From: Simon Davis
Sent: 15 May 2020 17:55
To: Peter Drury (Drew Smith) [REDACTED]
Cc: Daniel O'Shea (Drew Smith) [REDACTED]
Subject: RE: P/38/20/DOC - land to north and south of Summer Lane, Pagham

Regarding the electric charge points, I have re-read the SPD and my understanding is that it seeks:

DRAWING TITLE
GARAGE DETAILS - 1

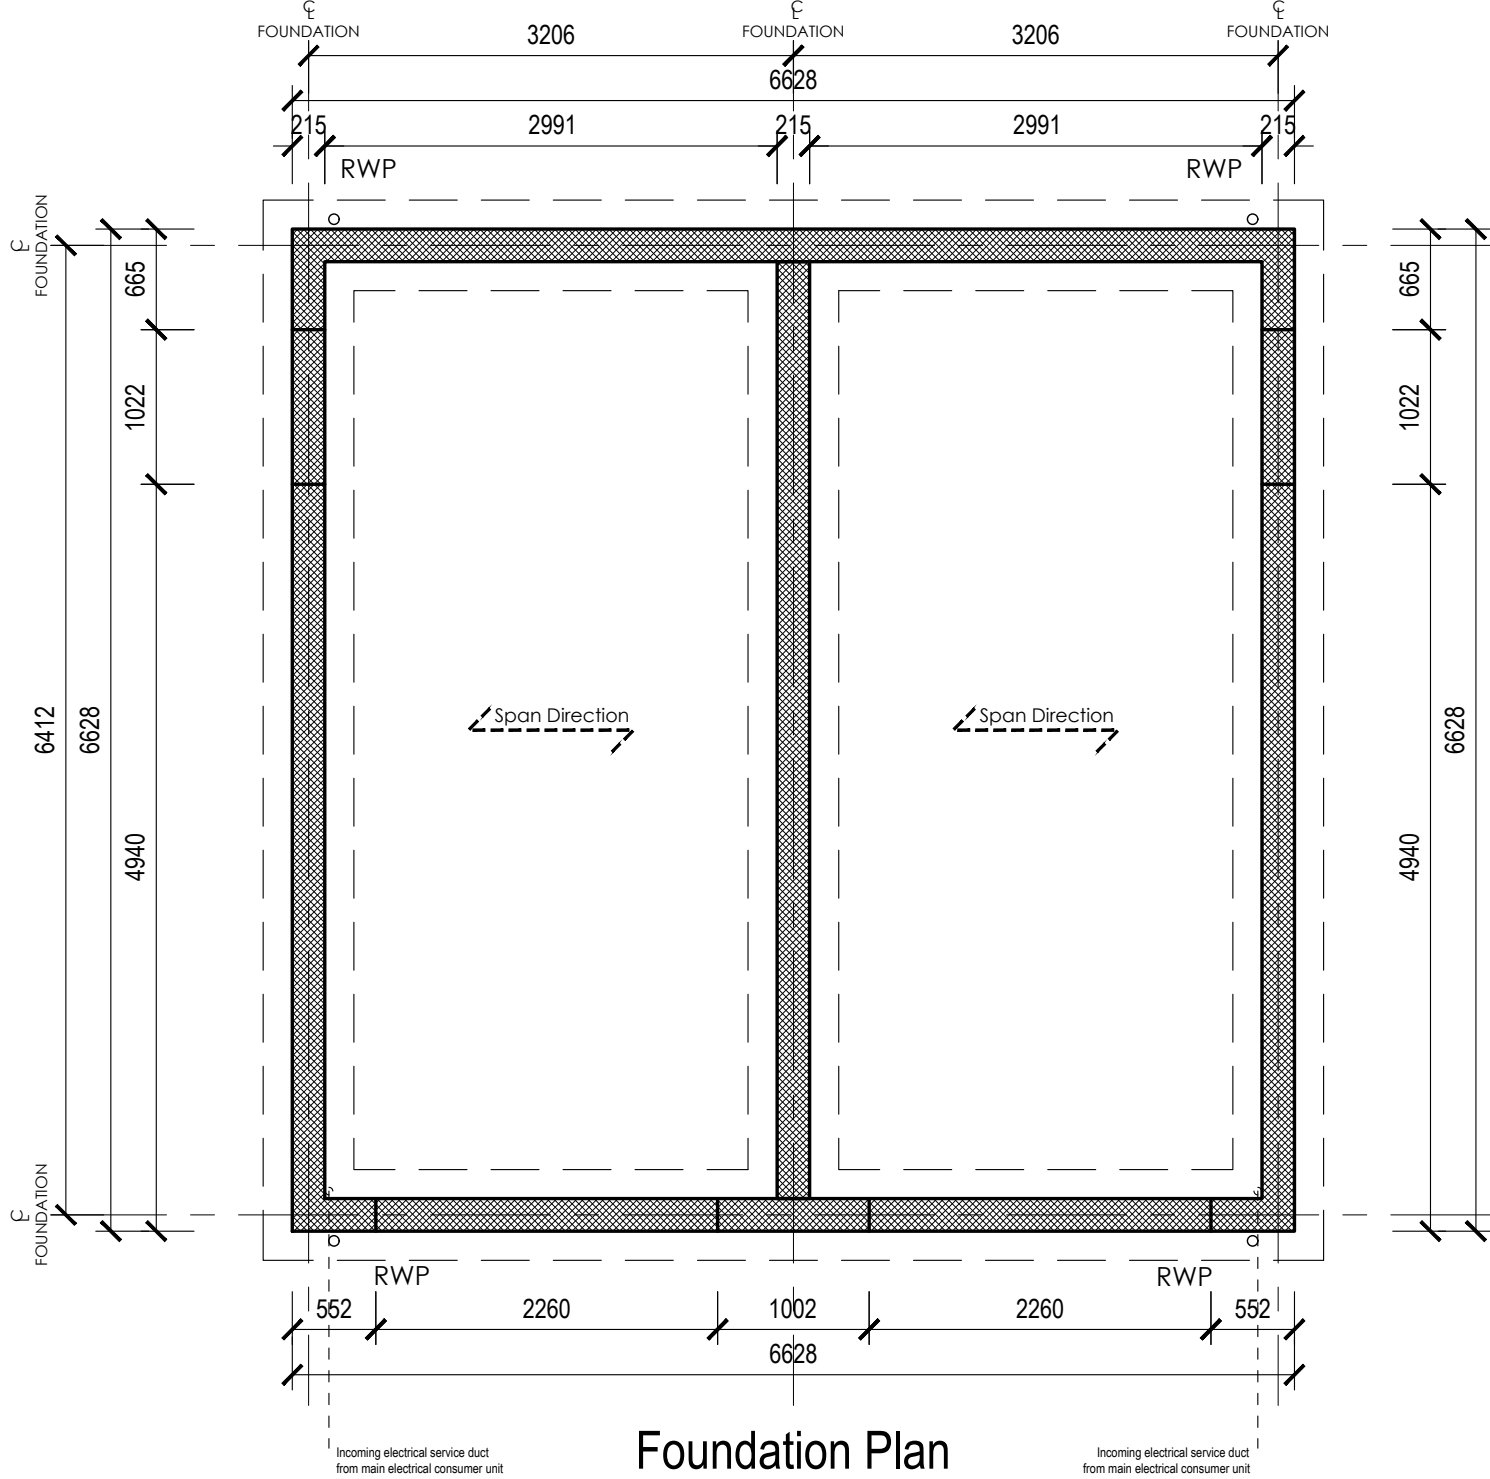
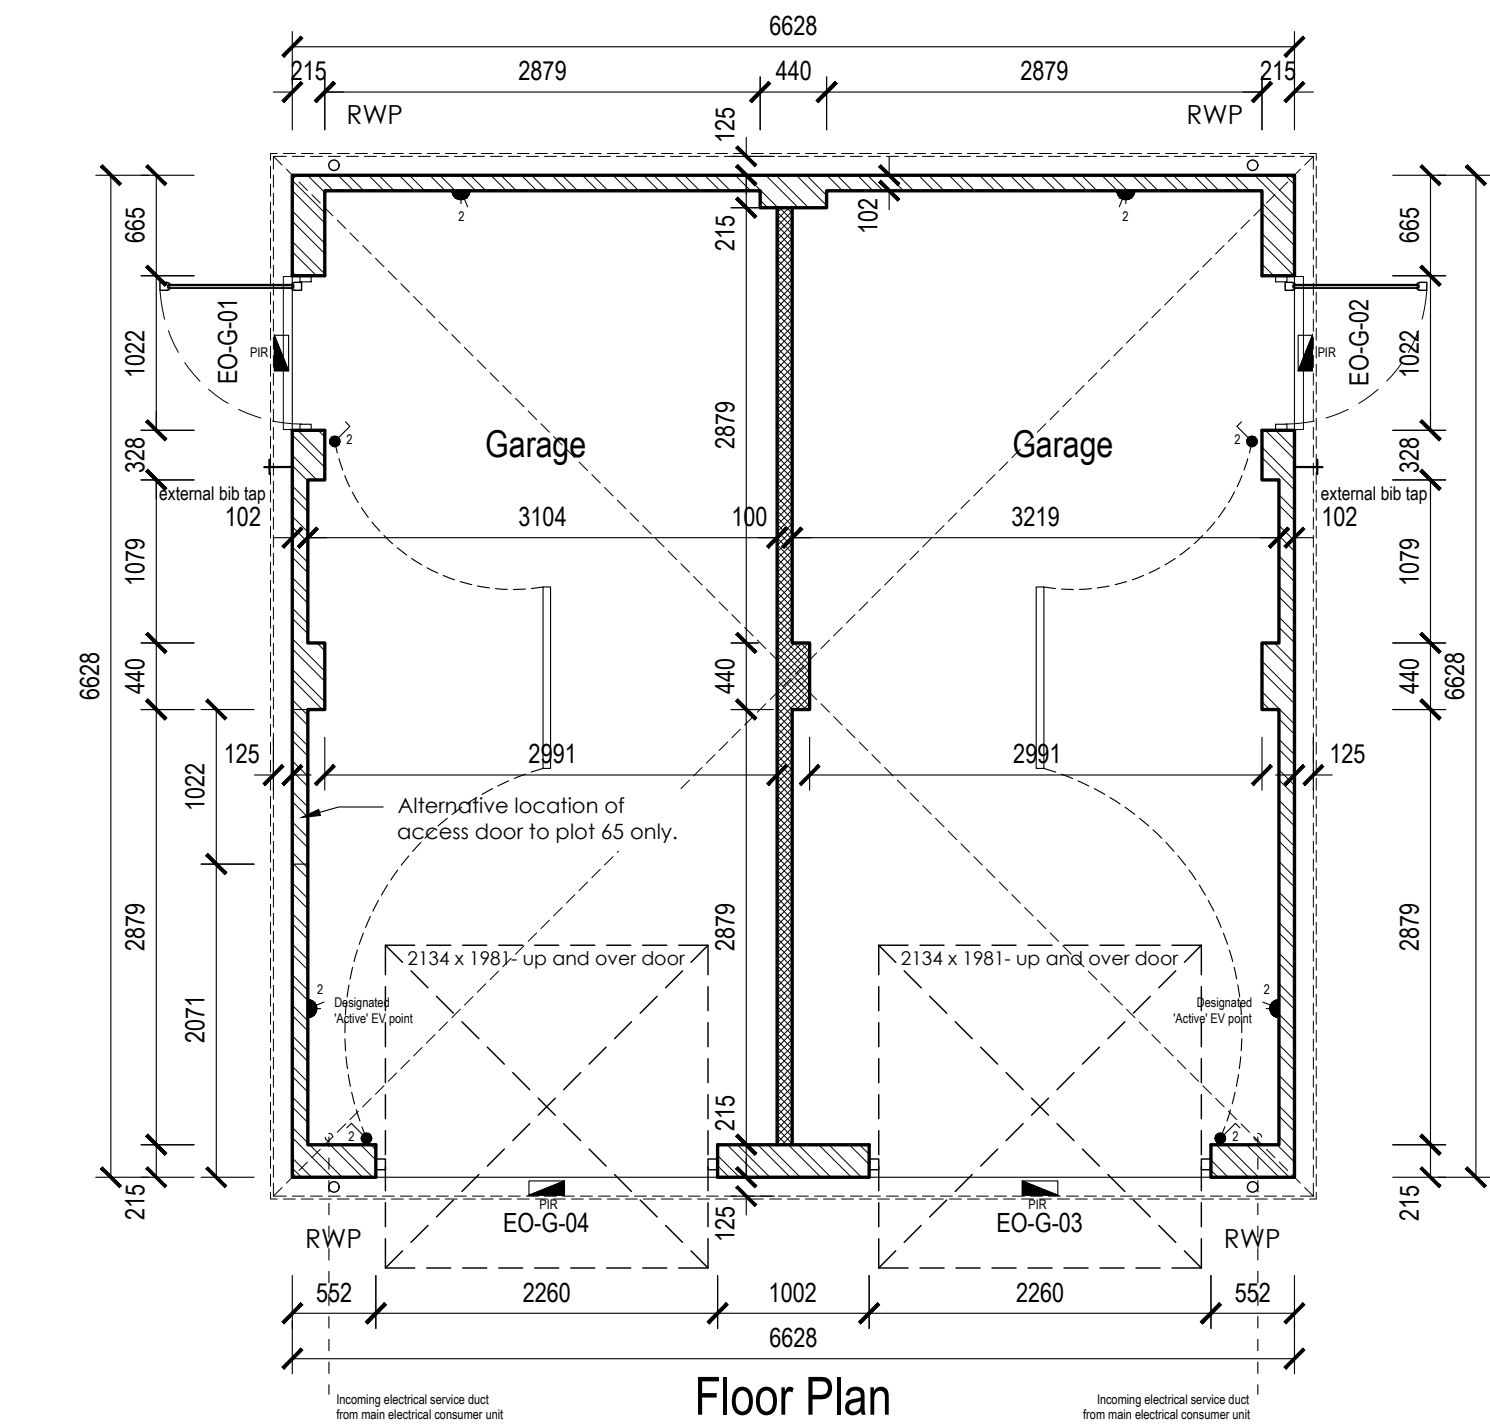
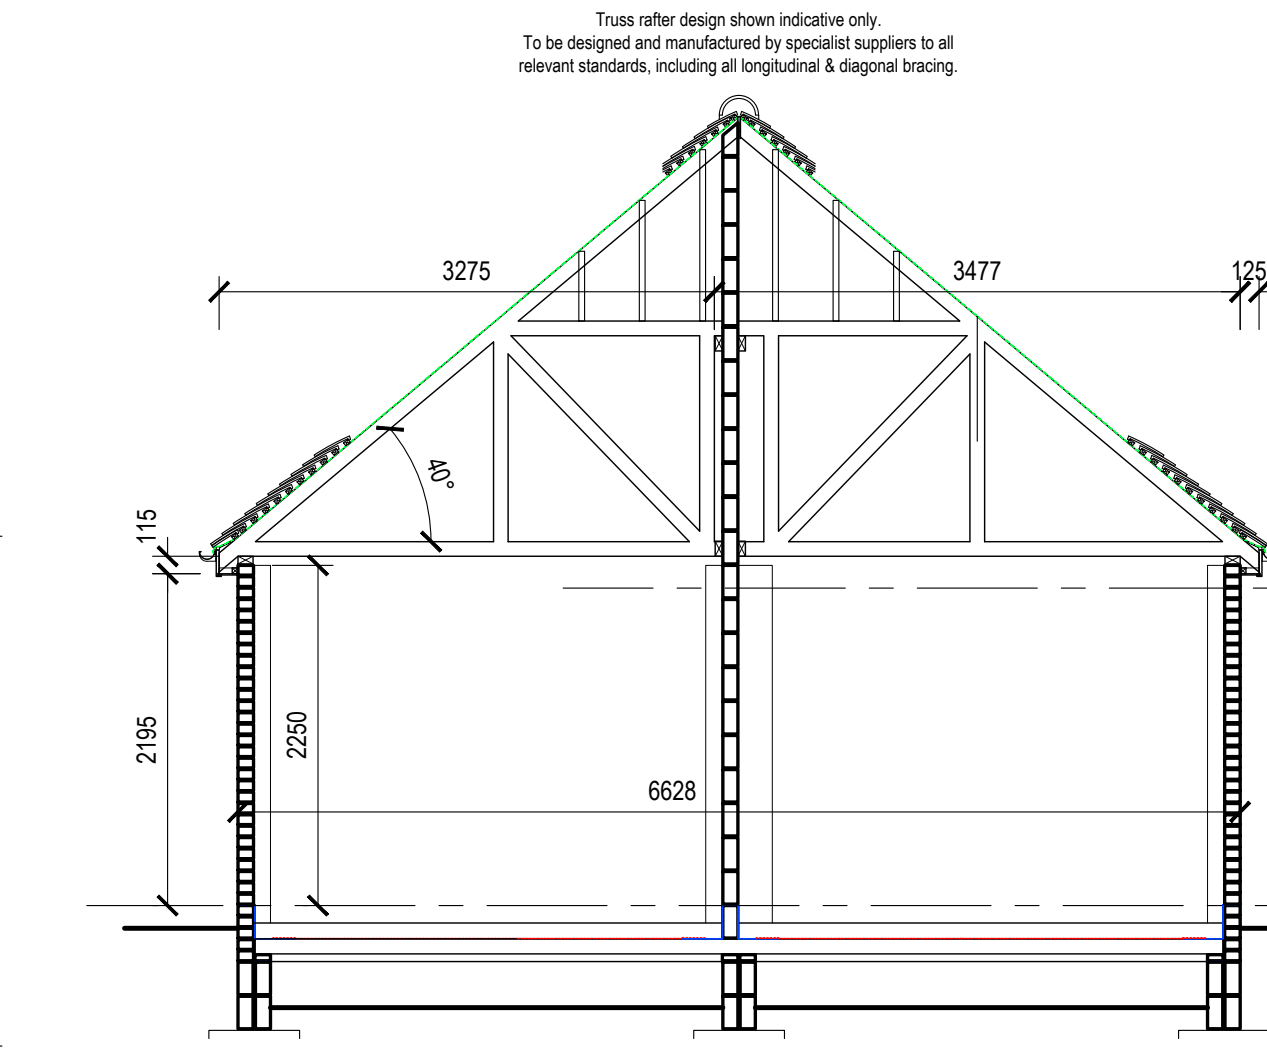
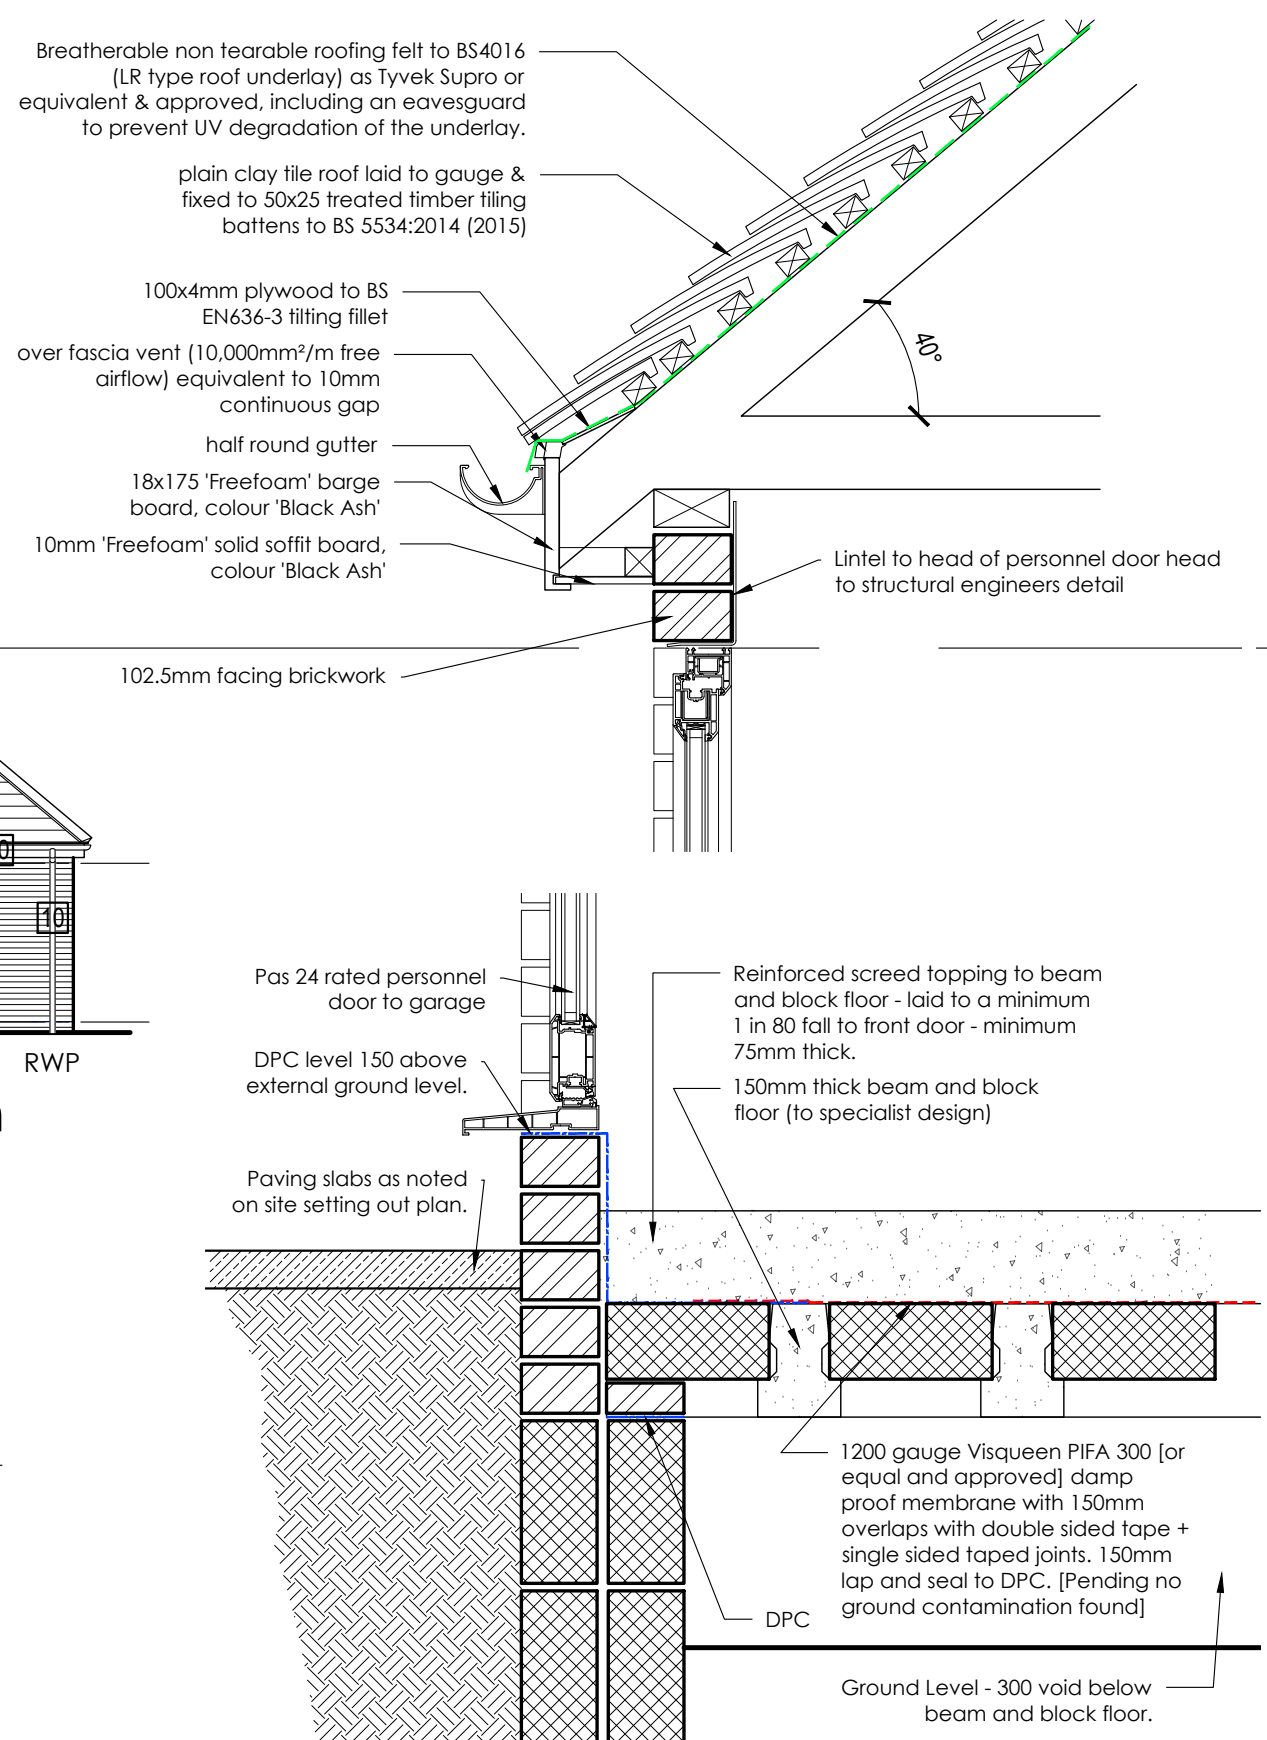
- 100% of parking spaces of houses with a driveway or garage require an active charge point (this reflects the correction of the typo)
- At the current rate until 2023, 20% of all other parking spaces should have an active point; and
- Ducting is provided at all remaining spaces where appropriate to provide 'passive' provision for these spaces to be upgraded in future.

You say that you have provided 100% of plots with garages with an active EV point within every garage, and then every plot with either a driveway or remote allocated parking space with passive provision. I appreciate the issue re the typo but it seems that there are other conflicts with the requirements of the SPD. Please consider and advise.

Can we agree that as the SPD has an error we can proceed with the current plan and as agreed by your email on the 12th May?
